Comment: Over-development, footprint and massing — Plot 23

I object to the proposed amendments to Plot 23 on the basis that they would result in over-development of the plot, both in terms of footprint and overall massing.

Front/south east facing elevation (1:100)

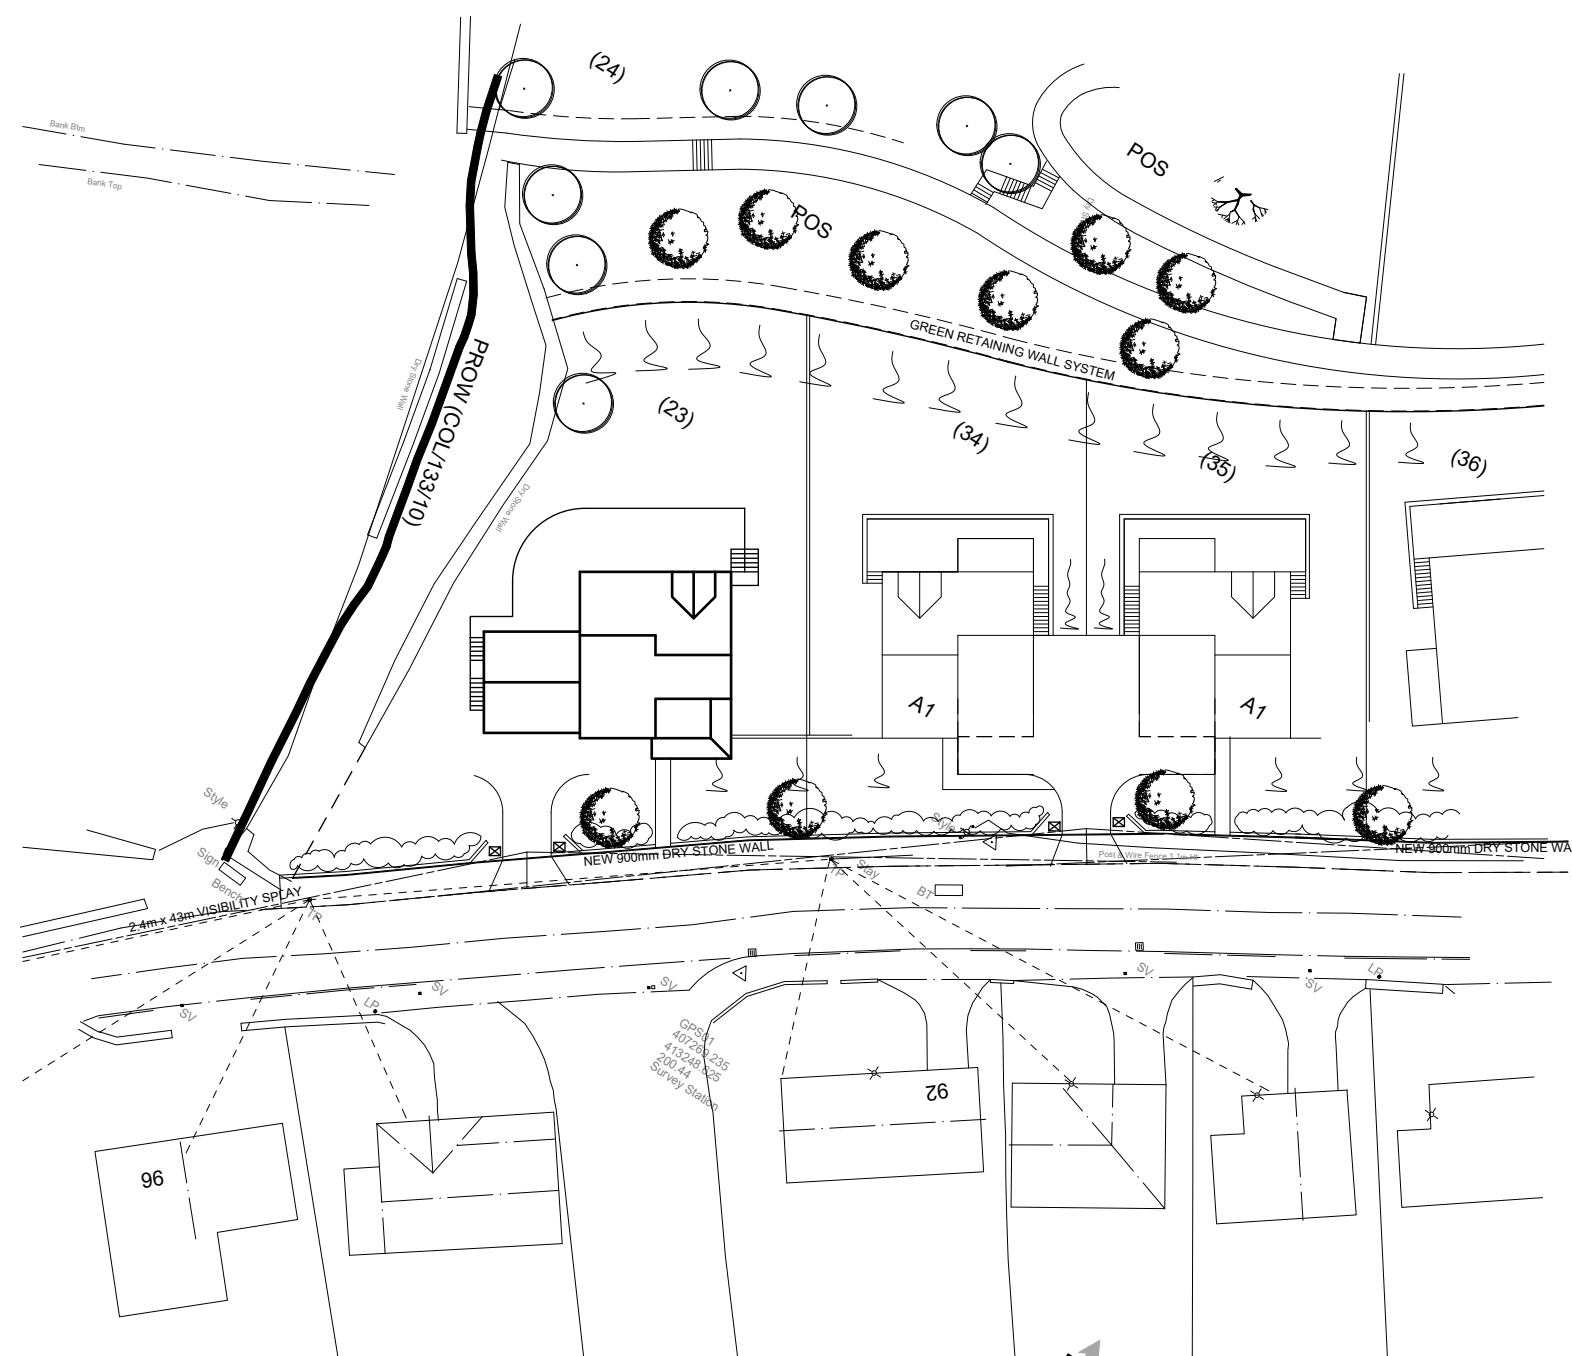
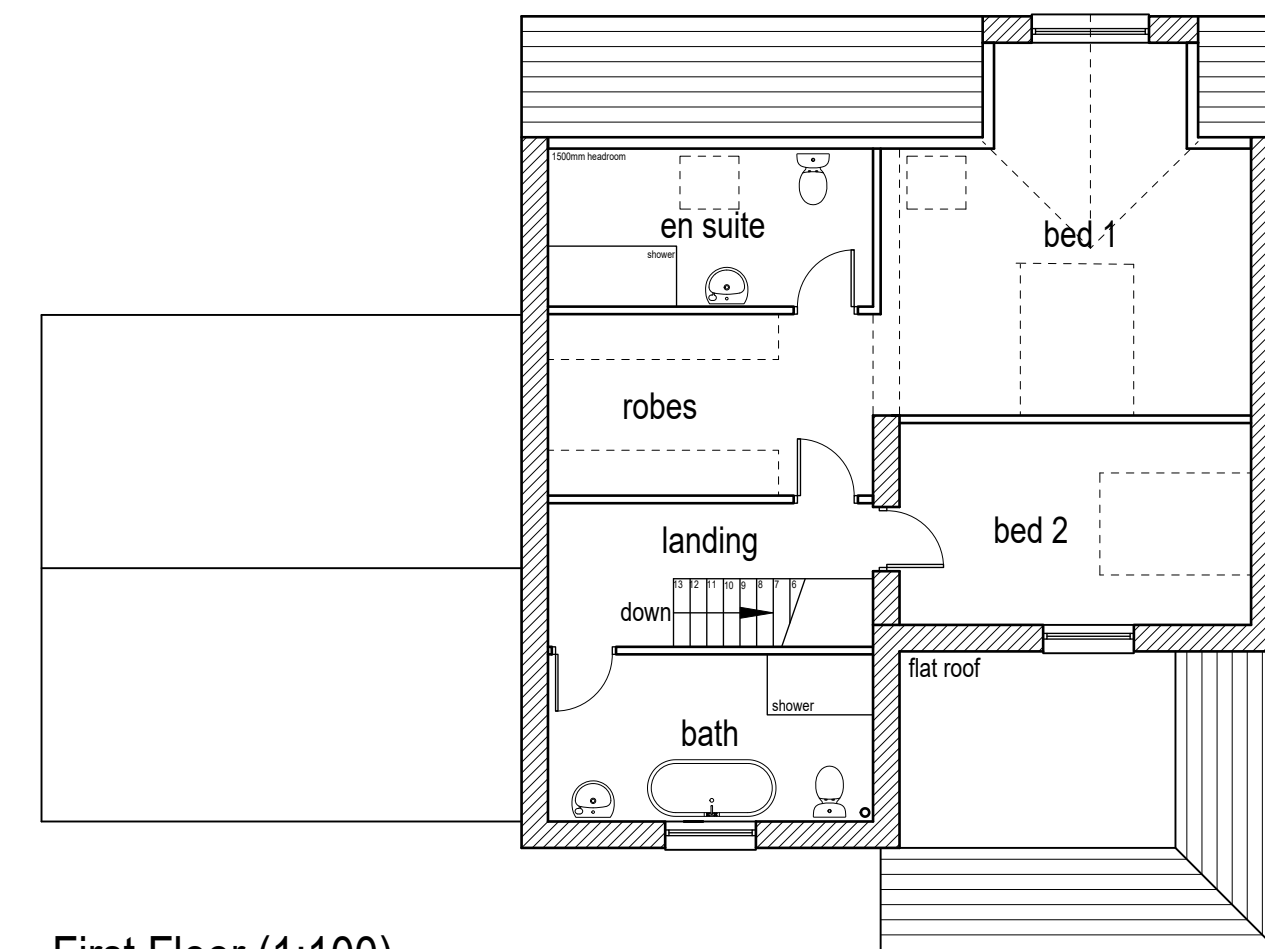
The applicant presents the proposal as a relatively limited alteration to provide a larger attached garage. However, the submitted material confirms that the existing permission was for a detached dwelling with a single garage, whereas the current proposal is to provide a double garage on the side of the dwelling. This is therefore not simply a minor design change. It materially increases the built form, lateral spread and visual weight of the dwelling.

Over-development is not assessed by footprint alone. The number of levels and the resulting massing are also material. The applicant's supporting statement refers to the new dwellings as being "two storey to the front and three to the back," relying on the hillside setting to justify the scale of development. That does not properly address the current proposal. The application appears to introduce a further lower-level garden room beneath the raised terrace, creating a four-level form in rear elevation terms. That additional level increases the apparent scale, bulk and intensity of the development.

The applicant's own statement records previous concern that the double garage would be an "overly large, dominant addition" and would harm the "space about dwellings" secured at the original application stage. Those concerns remain valid. The proposed double garage increases the lateral spread of the dwelling and further erodes the space around Plot 23. When combined with the raised terrace, retaining structures, hardstanding and lower-level accommodation, the result is an over-developed plot.

The over-development concern is also linked to the visual relationship with neighbouring dwellings. The double garage is not a neutral addition hidden within the approved building envelope. Its west elevation forms part of the outward-facing built form of Plot 23 and, when projected, intersects with the dwellinghouse at No. 94. This demonstrates that the garage has a direct spatial and visual relationship with dwellings opposite Lingards Road. It should therefore be assessed as part of the cumulative massing and amenity impact of the development, not dismissed as a minor garage alteration.
